Our Ref: P/25/18/PL

**Town & Country Planning Act 1990 (as amended)
Town and Country Planning (Development Management Procedure) (England) Order 2015
Application for Planning Permission**

Development Demolition of existing garage, roof alterations to existing dwelling to provide first floor & 1 No. new dwelling in garden of existing dwelling.

Location Jenin Nyetimber Lane Pagham

Peter J. Gardner Architectural Design Consultant	
	www.architecturaldesignsolutions.co.uk 07967 205249
Job Title	Jenin, Nyetimber Lane Bognor Regis PO21 3JT
Drawing Title	Proposed New Dwelling Floor Plans
Client	R.B
Date	12/05/2017
Drawn	P.J.G
Scale	1:100 on A3
Drq No.	NTL/P/01

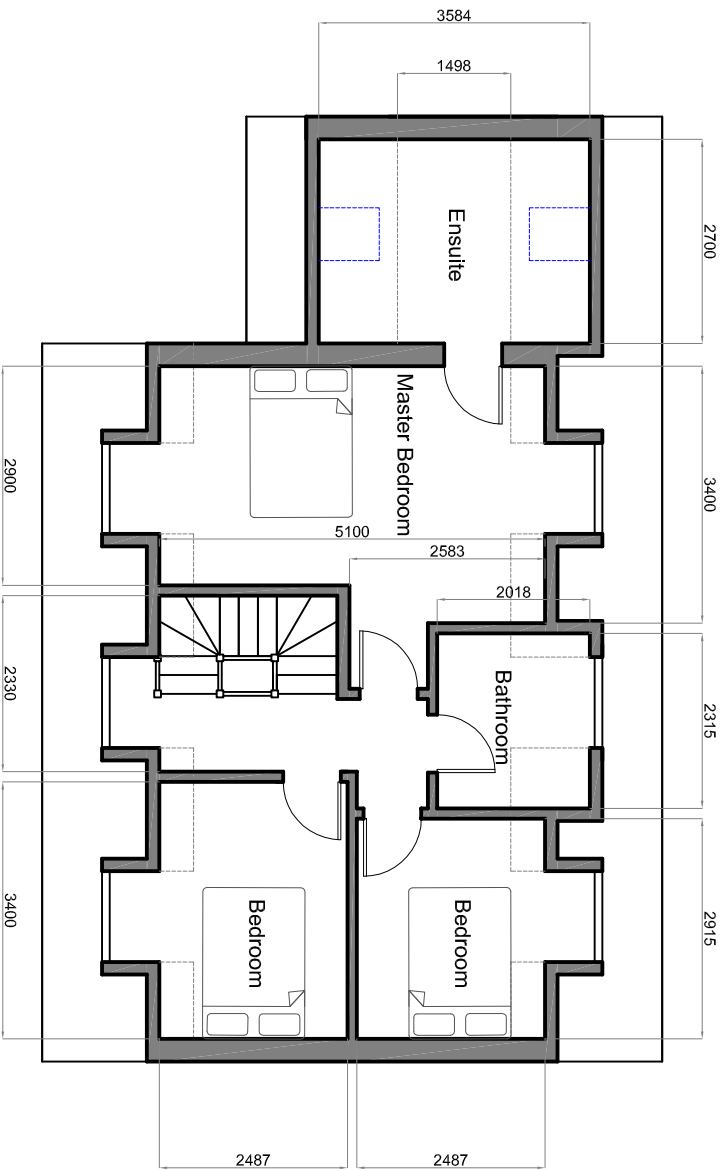
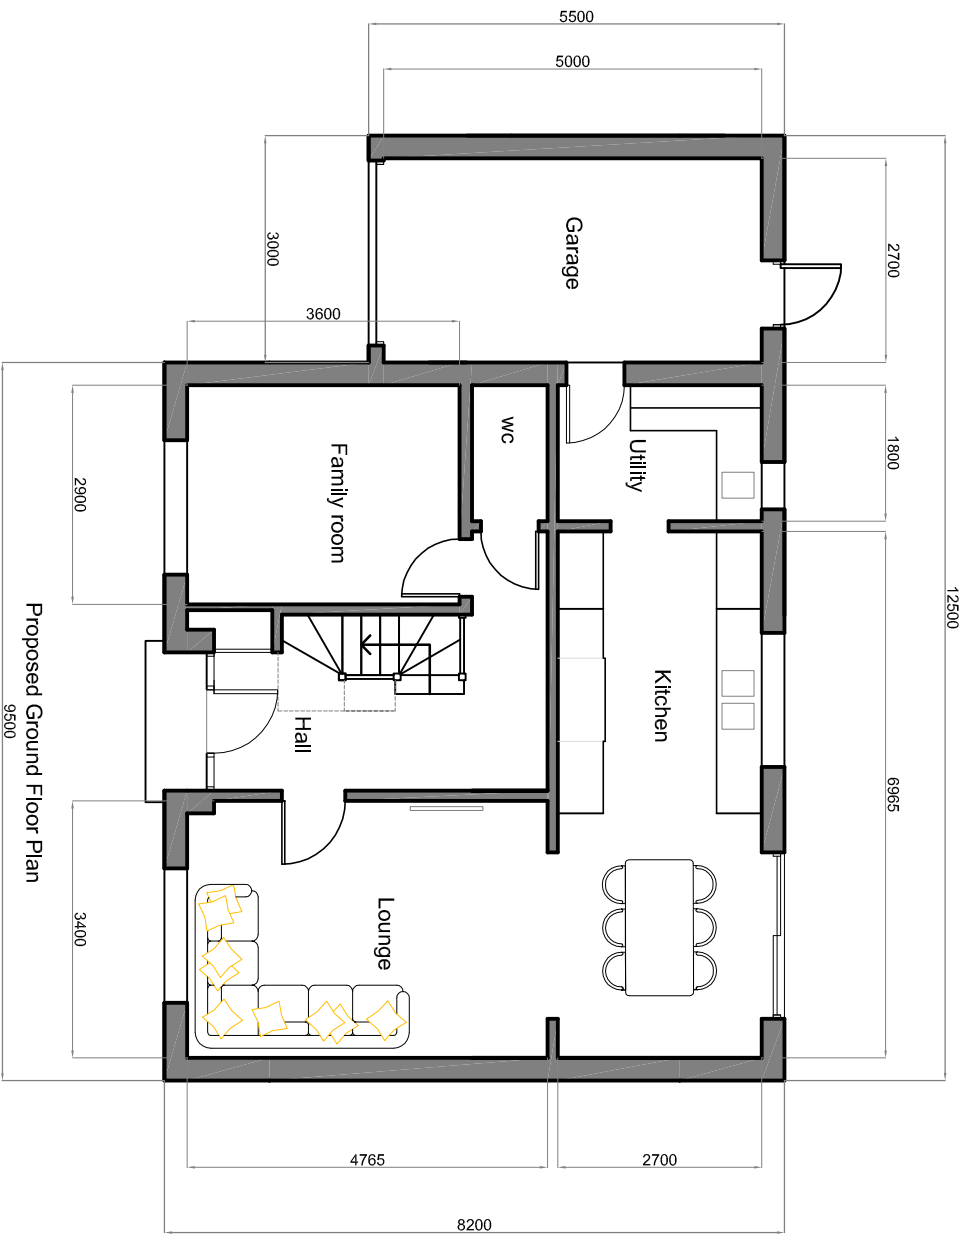
The proposed floor plans and elevations of the new house do not accord. Please check the floor plans and elevations and make the changes accordingly.
